From:
To: [DCAdmin](#)
Subject: Planning Application 2022/70/93974
Date: 17 February 2023 13:17:44

The above application is for a variation of conditions on application 2021/91239 and to relocate the garage/home office of 412 Birkby road

client	MR S.HANDA		
project	PROPOSED GARAGE 412 BIRKBY LANE HUDDERSFIELD HD2 2DN		
drawing	PROPOSED SITE PLAN		
revision	notes	date	drawn
A	SITE SECTIONS	12.22	MG
scale :	1:200 AT A1	12.22	-
project no.	drawing no.	revision	
2189	02	A

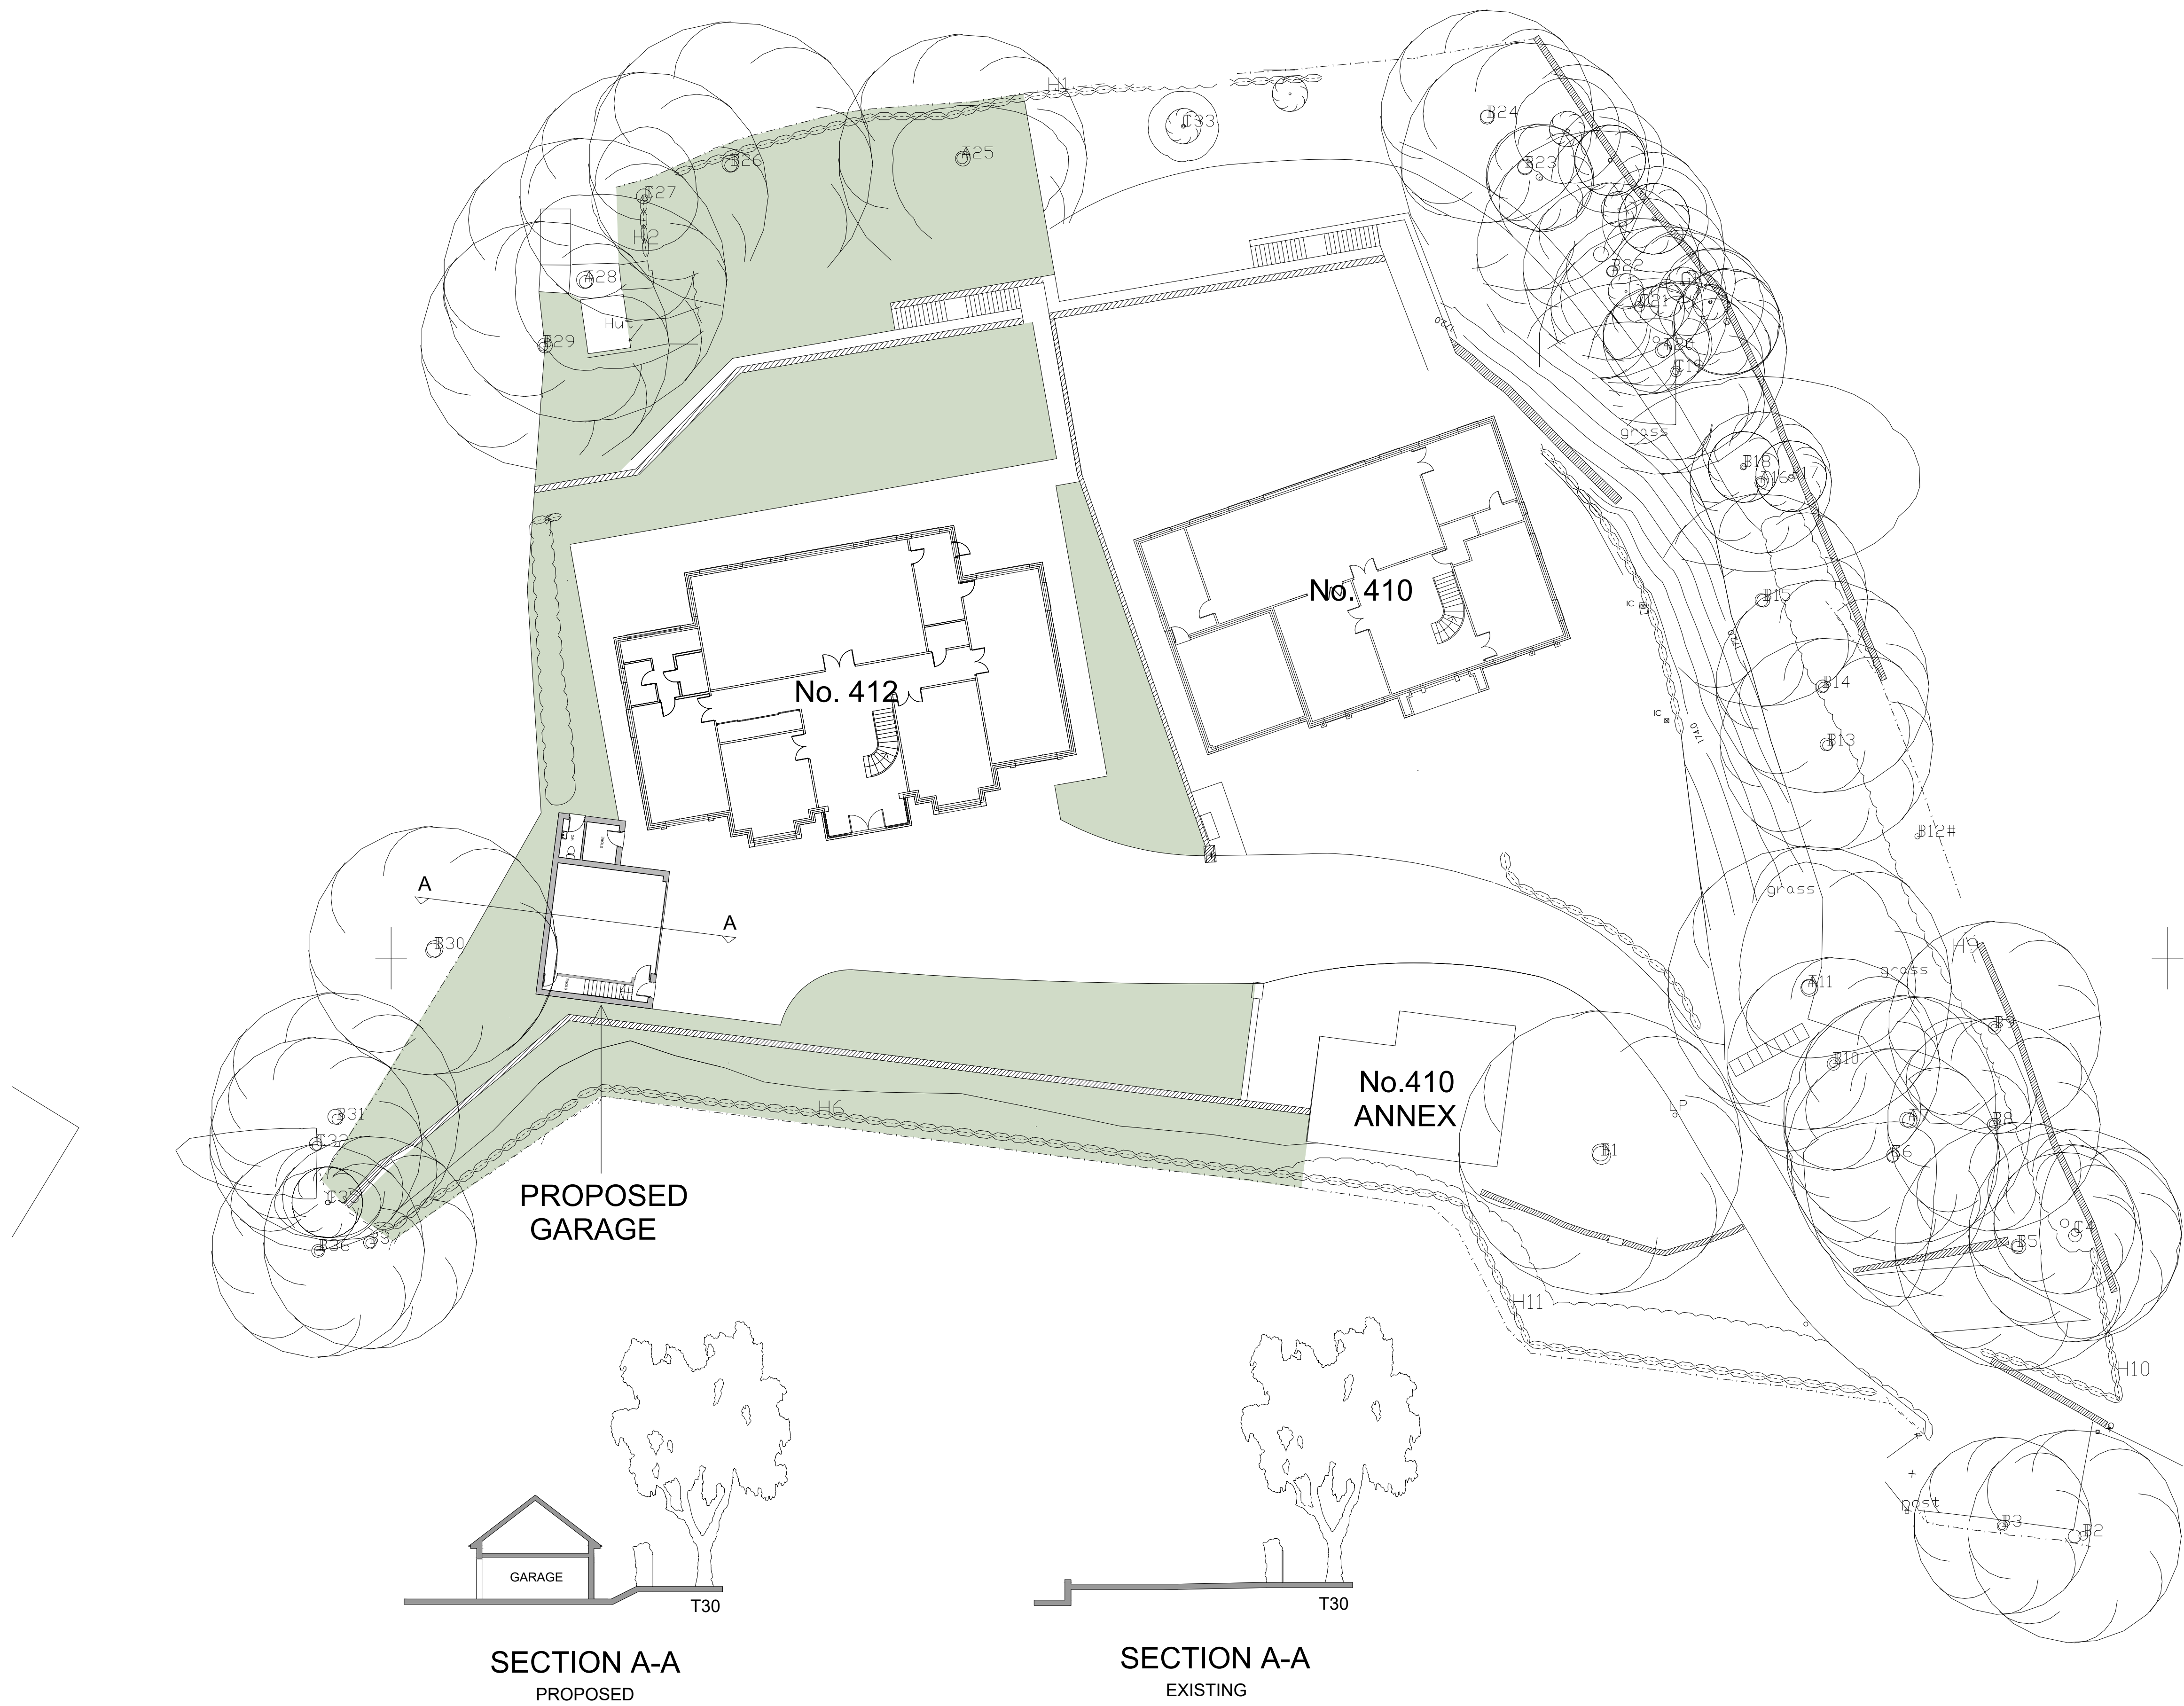
This variation of condition application appears to move the garage back to exactly where it originally was in the 2021 plans - adjacent to tree T30. See superseded document 863478 dated 8/4/21 of 2021/91239

(not tree T1 as quoted in the new arboricultural report. Tree T1 was adjacent to the garage of 410 and has already been felled)

A formal Consultee response from Kirklees Trees is therefore obviously needed now that this new application appears to move the garage back to a position that was not acceptable to them in 2021
